Development Application and Planning Proposal Review NSW Planning Portal Concurrence and Referral

Authority	Authority's Reference	Agency Concurrence and Referral	Authority Contact	Authority Notification	Submission Due	Submission Made
NSW Dept. of Planning Housing & Infrastructure	SSD-30628110		Bruce Zhang	15/03/2024	15/04/2024	15/04/2024

Address	Land Title
706-752 Mamre Road, Kemps Creek	Lot 1 DP 104958

Environmental Impact Statement (EIS) for the Summit at Kemps Creek – 706-752 Mamre Road. A Concept Proposal comprising nine buildings with a total gross floor area (GFA) of up to 244,413 square metres (m2) and Stage 1 development of three buildings with a total GFA of 79,263 m2.

Figure 22 Stage 1 Development

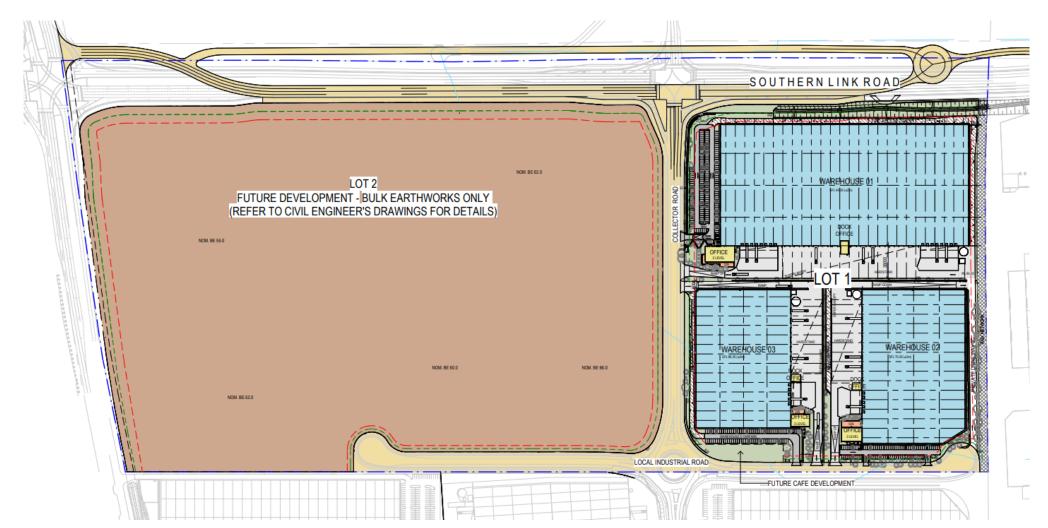
- The below extract of the Stage 1 Masterplan shows provisions for three padmount substations. However this does not appear to be addressed further in either the EIS or the Civil Infrastructure Report.
- Endeavour Energy's Asset Planning and Performance and Customer Network Solutions Branches have provided the following advice:
